Re: Wind energy development including 19 no. turbines and all associated works.
Townlands of Clogherachullion, Cloghercor, Derryloaghan, Aghayeevoge, Cashelreagh Glebe,
Darney, Drumard, and Drumnacross Co. Donegal.

Your Ref: ABP-316025-23
Our Ref: SID-2023-DG-03
(Please quote in all related correspondence)

| Proposed Strategic Infrastructure Development (SID): proposed Development of Cloghercor Wind Farm at Cloghercor, Co Donegal |

Further to the observations that were issued to you on 08/05/2023 please find attached further observations of the Department in relation to Nature Conservation.

Title: Figure 2-3: Turbine Delivery Route

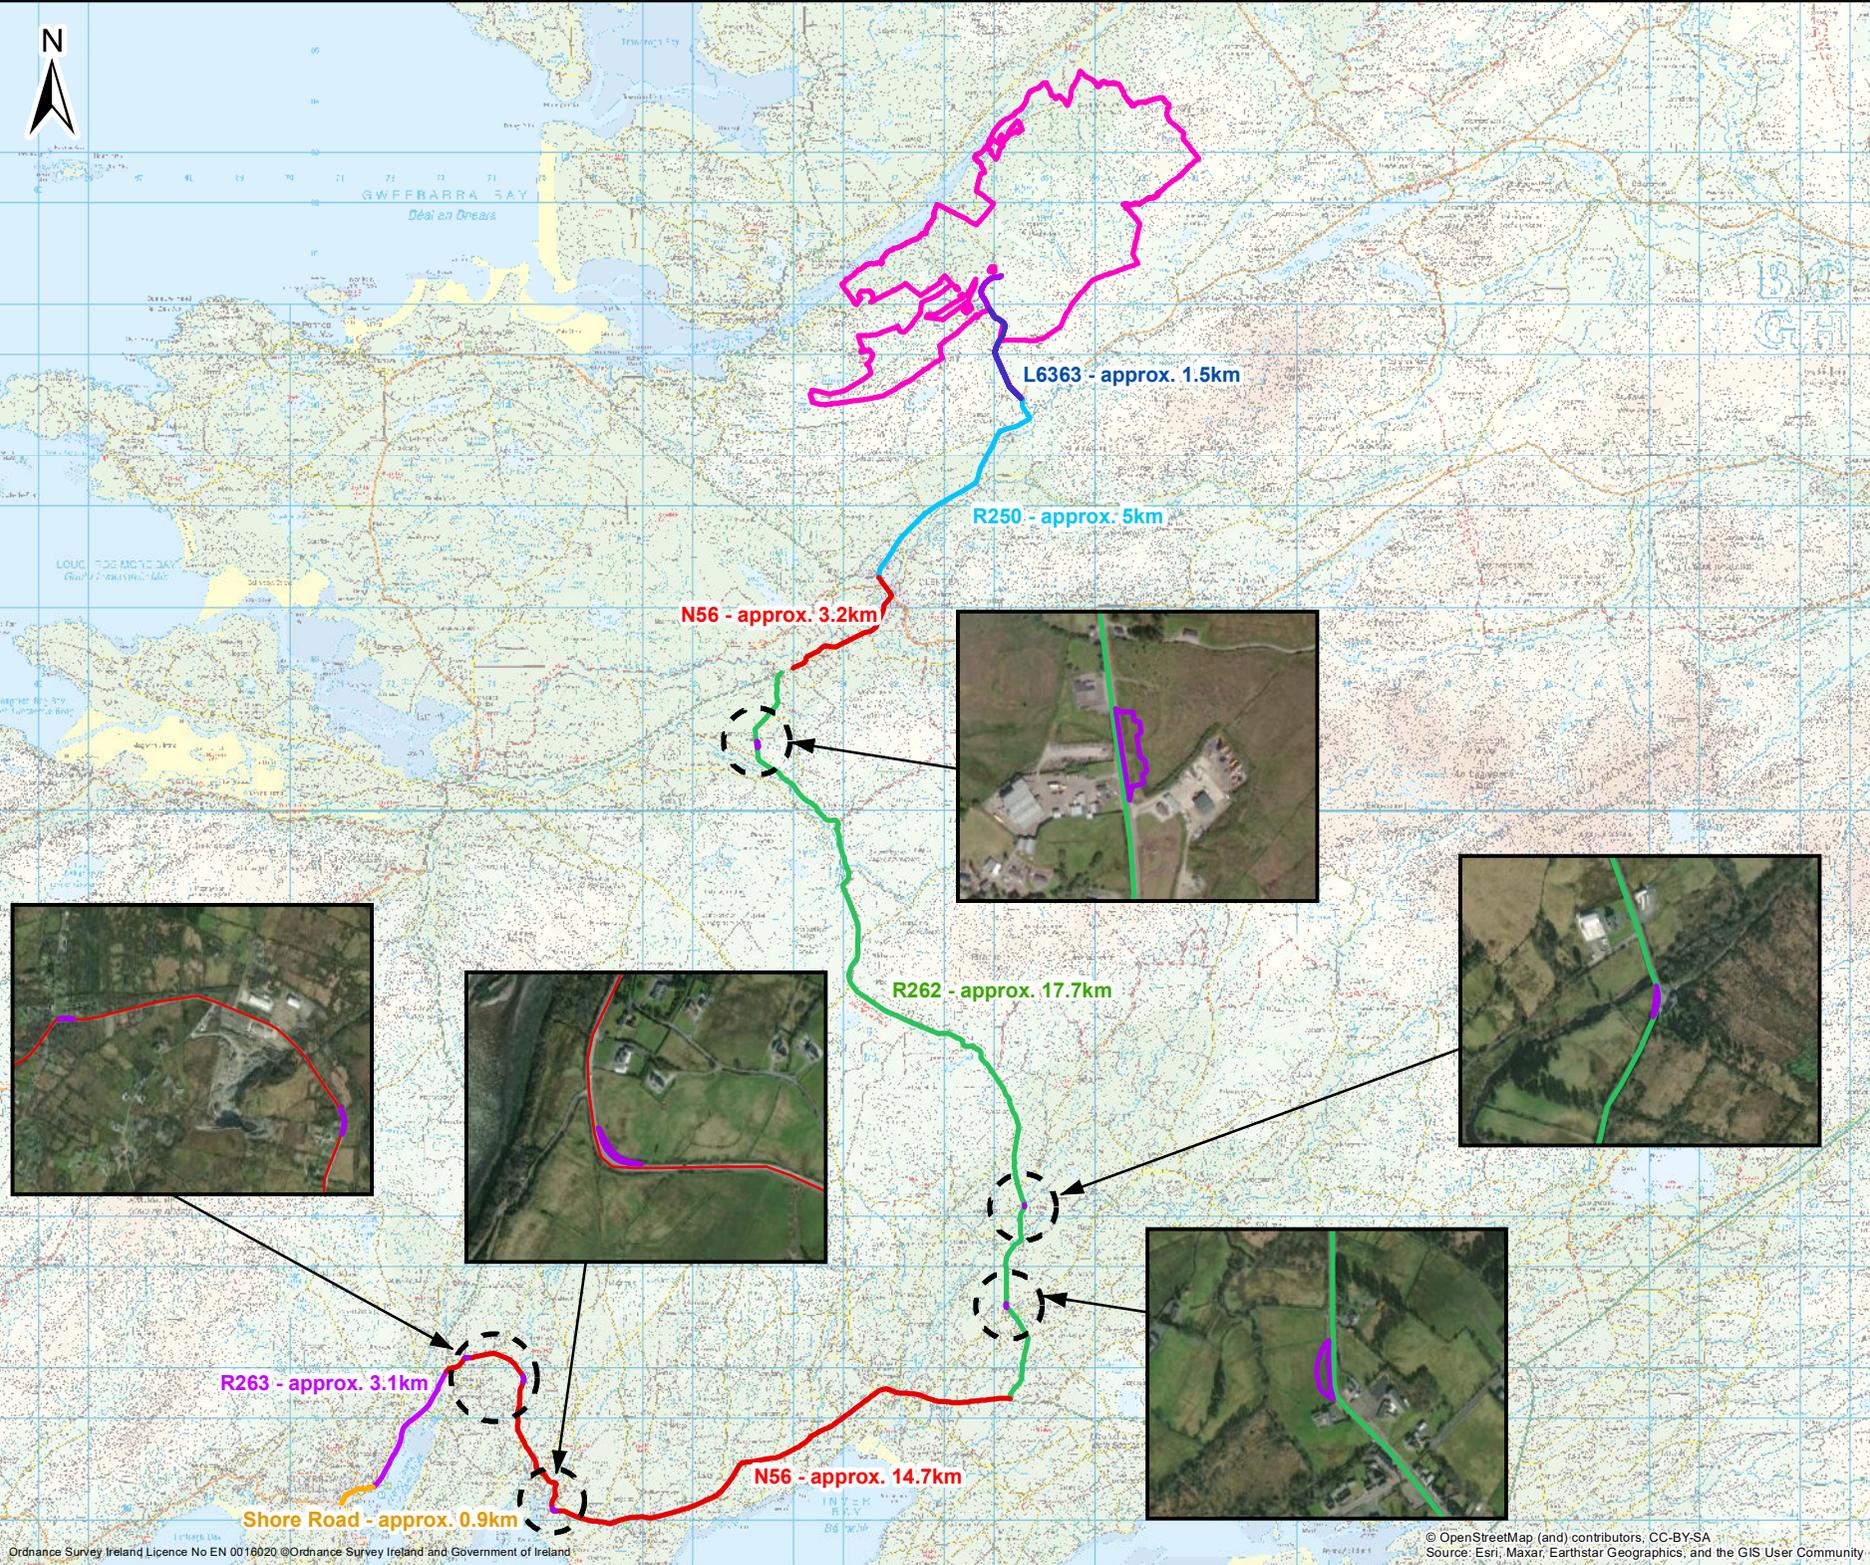
The transportation plan shows requirements for the crossing of multiple bridges to reach the proposed site. The Department is unaware of any assessment of the works needed to address bridge integrity on the haul routes protected species. Species such as bats, dipper and grey wagtails use the vital gaps in the undersides of bridges for roosting and breeding. Many of these old bridges may need bridge maintenance to accommodate the transportation plan for haul routes and turbine delivery route. Un-assessed and un-informed maintenance on these bridges can significantly affect the bats and birds relying on these bridges for breeding. There is at least one bridge identified by the RSA assessment (Appendix 2-1 of Traffic and Transport, Chapter 16), but there is no evidence of an assessment of this bridge for upgrade or wildlife. There is no reference to ‘bat’ or ‘bird’ in this chapter, nor in the Traffic Management Plan (Appendix 2.7). This suggests that an assessment of potential cumulative impacts to protected species has not been carried out on the haul routes or turbine delivery route.

Figure 1 - Quaternary geology

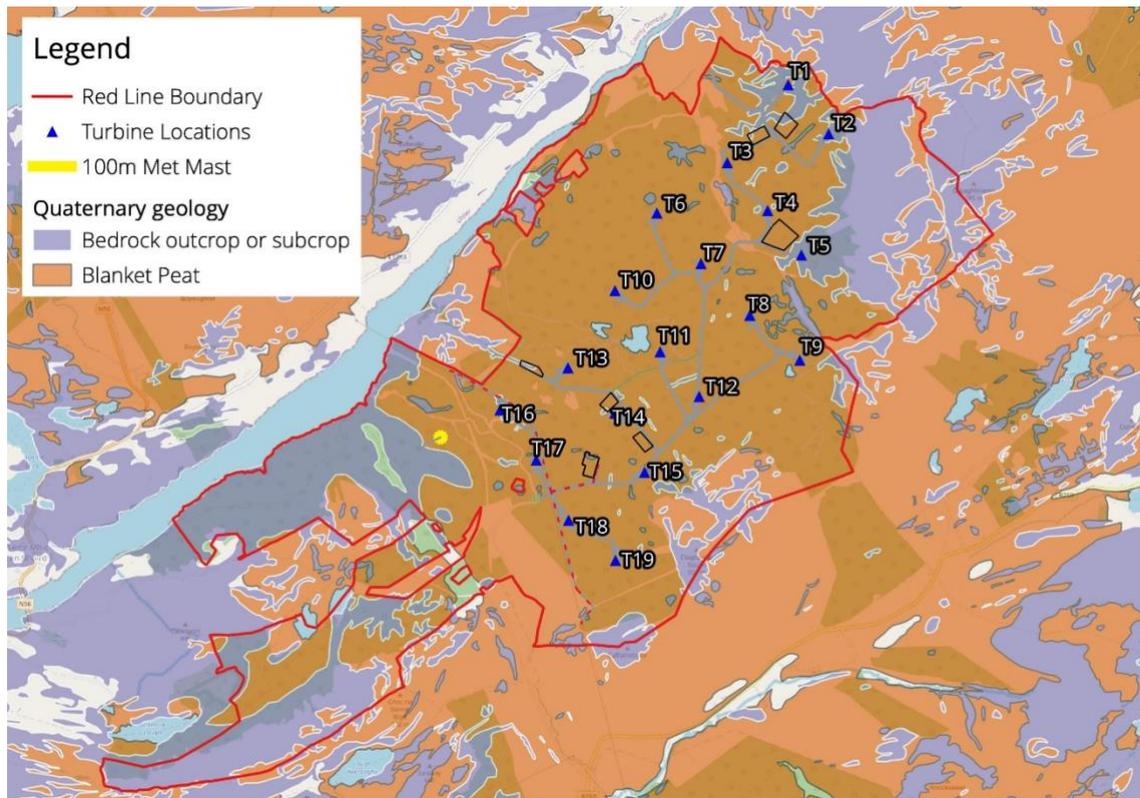
The Peat Stability Risk Assessment is noted (Appendix 2-9). The Department notes that most of the turbines are located on blanket peat (Fig 1, p. 10 Quaternary Geology Peat Stability Risk Assessment), with five separate watercourses draining from the proposed site into the Gweebarra salmonid River, part of the West of Ardara/Maas Road SAC. Proximity to a water course is used to assess the risk of peat stability at individual infrastructure elements in Section 5 of the report. Two are in areas of “high” landslide susceptibility and fifteen are in areas of “moderately high” susceptibility (p13, App 2-9).

Figure A7.9.1 - Golden Eagle habitat management plan lands.

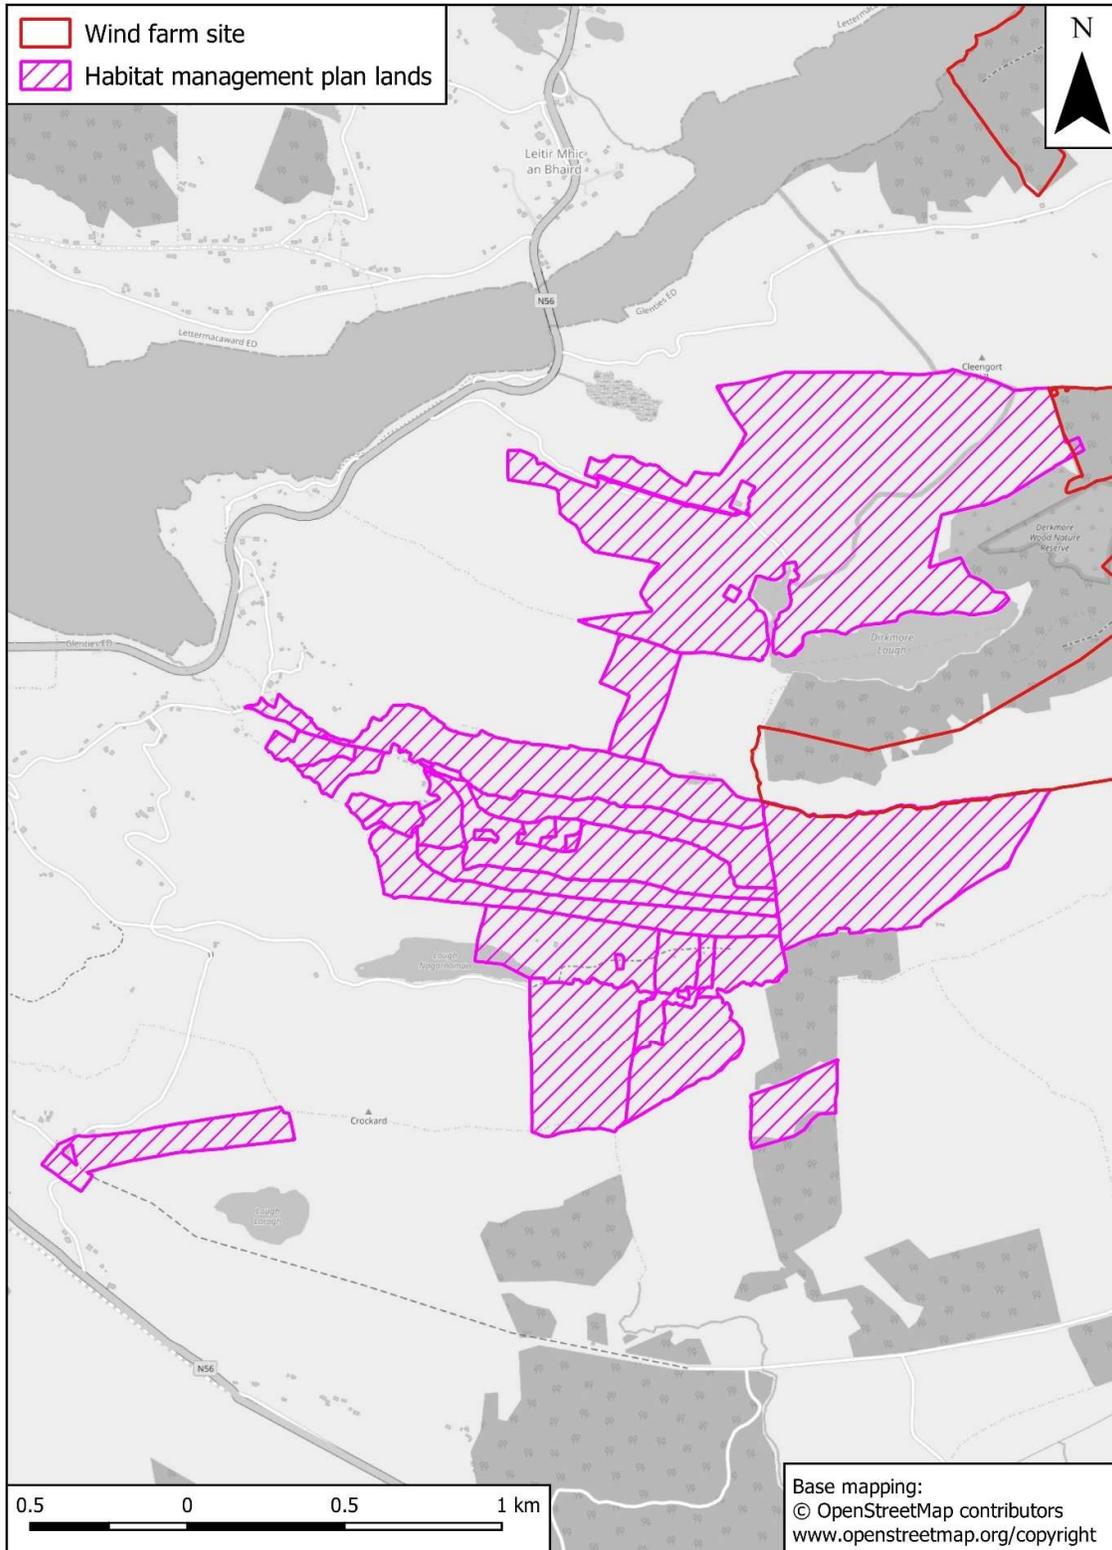
Regarding the Mitigation of displacement impacts to Golden Eagles, a Golden Eagle habitat management plan is proposed to compensate for the potential displacement impacts to Golden Eagles (see Appendix 7.9). The lands included in the Golden Eagle habitat management plan comprise 252 ha of bog and heath habitats (Figure 7-25), located immediately to the west of the application site. The total area of the indicative home range is around 90 km², or 9000ha, which is significantly larger than the 252ha Golden Eagle habitat management plan, and no assessment of potential nest sites in this area was presented. Studies from Scotland dismiss the theory that Golden Eagles become habituated to wind
